From: Liz Rogers [REDACTED]
Sent: 30 April 2018 09:12
To: Planning.Responses
Subject: RE: Planning Consultation on: A/40/18/OUT

App No: A/40/18/OUT

Address: Land North of Water Lane Angmering

Proposal: Outline application with some matters reserved for the development of up to 525 residential dwellings (Class C3), 3 ha (gross) of employment land (Class B1), public open space, play areas, access, associated infrastructure and landscaping.
Departure from the Development Plan.

Figure 2: Location of the active and inactive badger holes

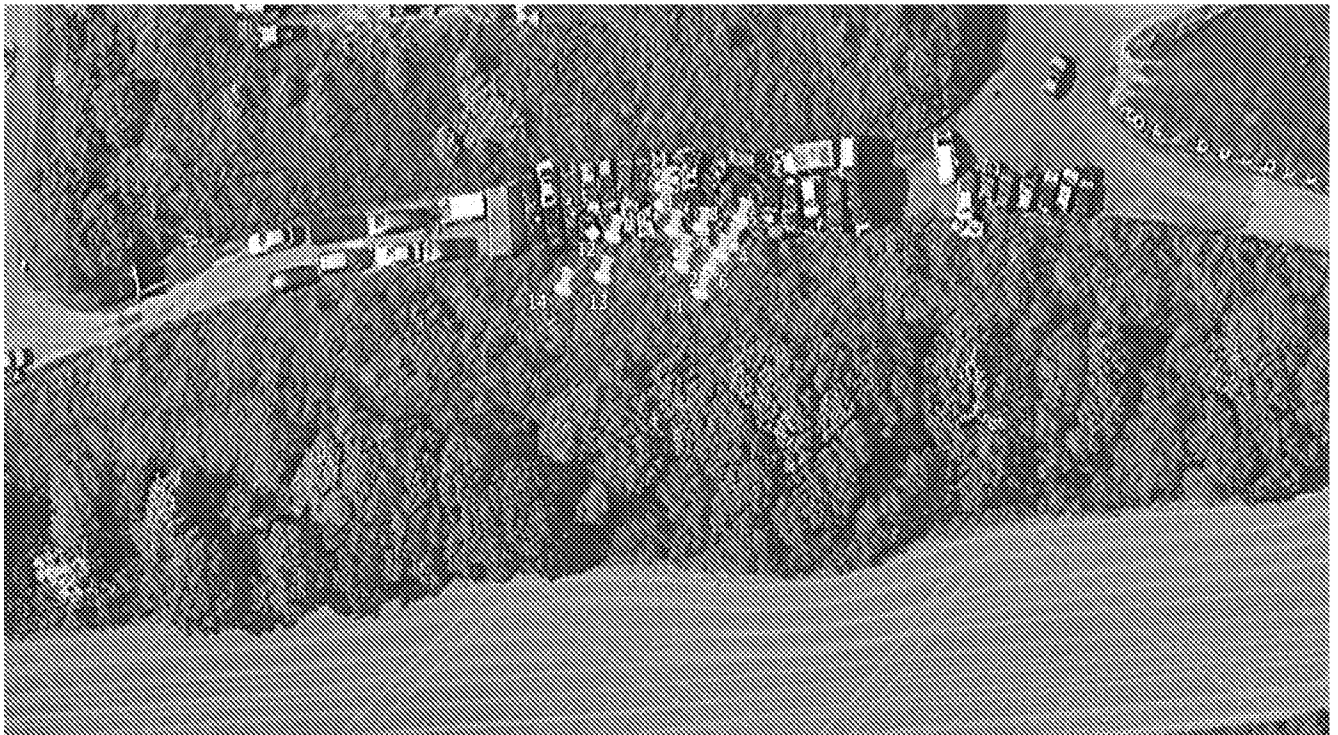
A 20m buffer must be maintained from the badger sett within the site. We require that as part of the reserve matters application that a full management plan for this sett is submitted, which will need to include further details on the following;

- Planting- with a range of species which badgers are known to forage from as well as thorny species to protect badgers from new residents and pets
- Fencing around the buffer zone to encourage badgers to avoid the construction site and instead forage and commute across the adjacent groom's copse
- Trenched covered, and open pipes blocked
- Restricted working hours to between dawn and dusk
- Minimise any works within 30m of sett
- Tool box talk details
- Badger friendly fencing should be used in the boundary fencing of Grooms Copse to ensure connectivity is retained post development
